Please ask for: Ms Iqraa Malik
Email: iqraa.malik@terraquest.co.uk
Telephone: 0121 234 1390
Our Ref: K/8/25/HH
Your Ref:
Date: 28th April 2025

Application for Planning Permission for Works or Extension to a Dwelling

Development: Demolition of existing garage and replacement with new extension, infill addition to front of property. Reconfiguration of fenestration to rear elevation. Replacement of existing cementitious hung tiles to facade, and installation of PV array at roof level.
Location: The Salterns 8 Coastal Road Kingston BN16 1SJ

2 Proposed Block Plan
Scale: 1:200

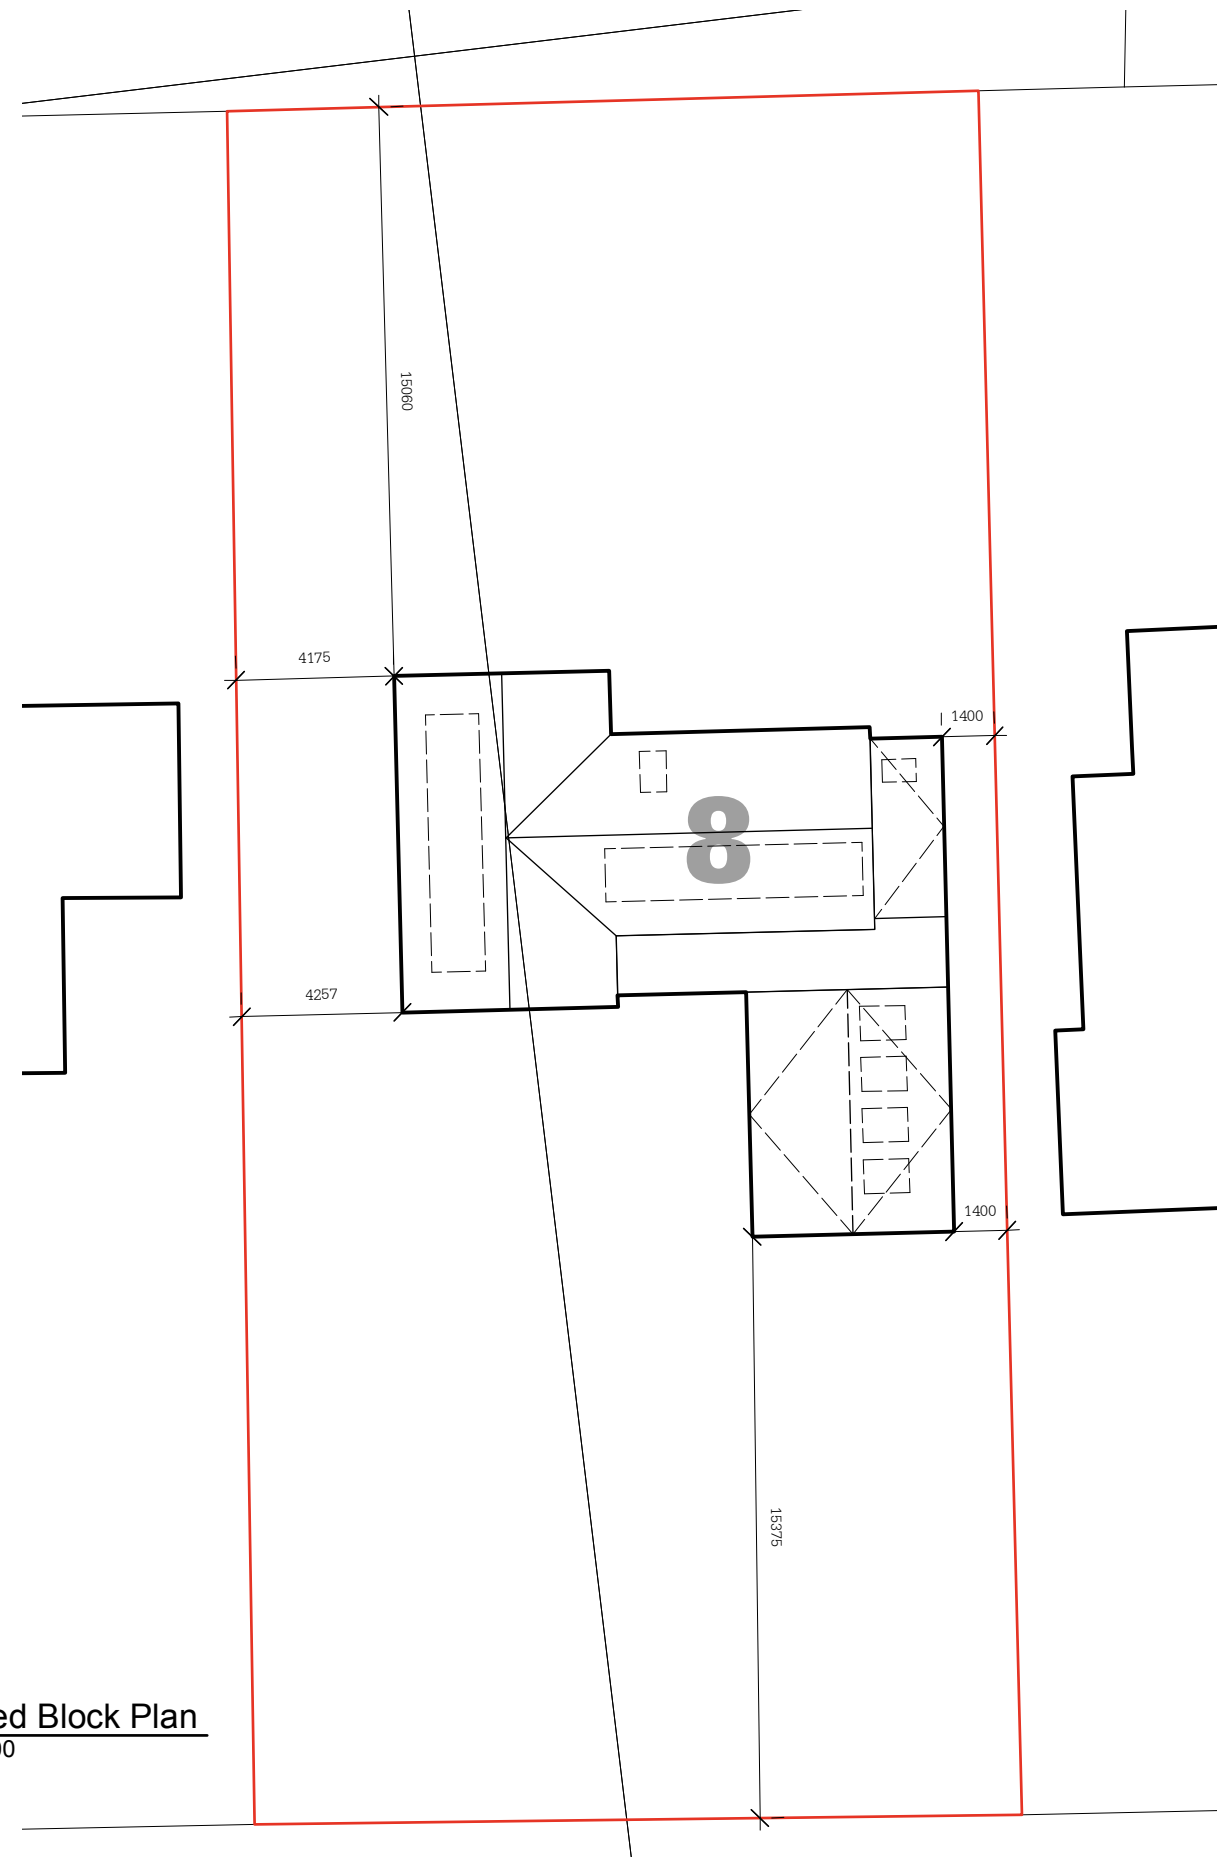
You are required to have dimensions from the proposed extension(s) to all site boundaries. Please amend.

DRAWING TITLE	PROJECT NO.	DRAWING NO.
Site Plan	21012	S.00
STATUS	DATE	REVISION
PLANNING	03.2025	-

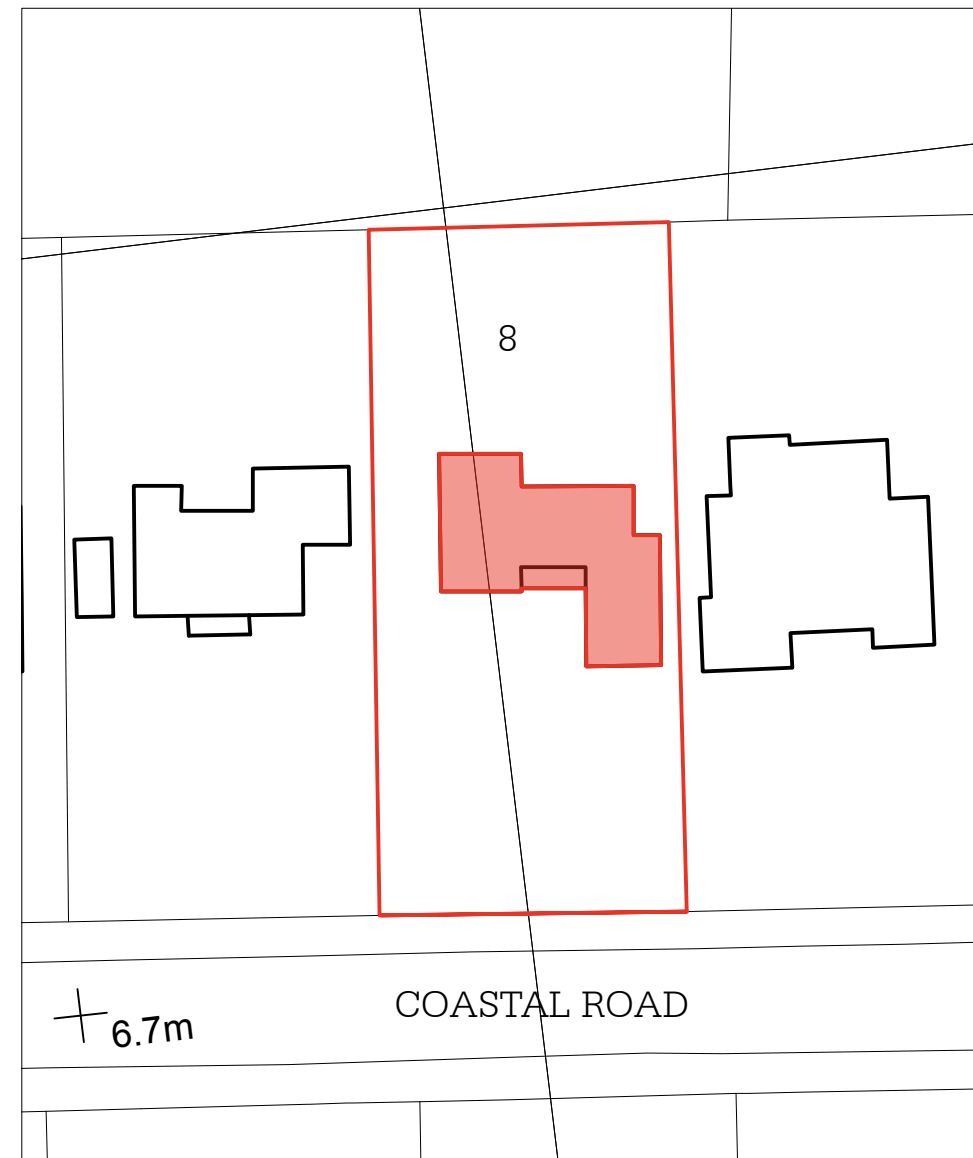
The site plans require a solid red outline around the entire site boundary, not only the dwelling, please review and amend accordingly.
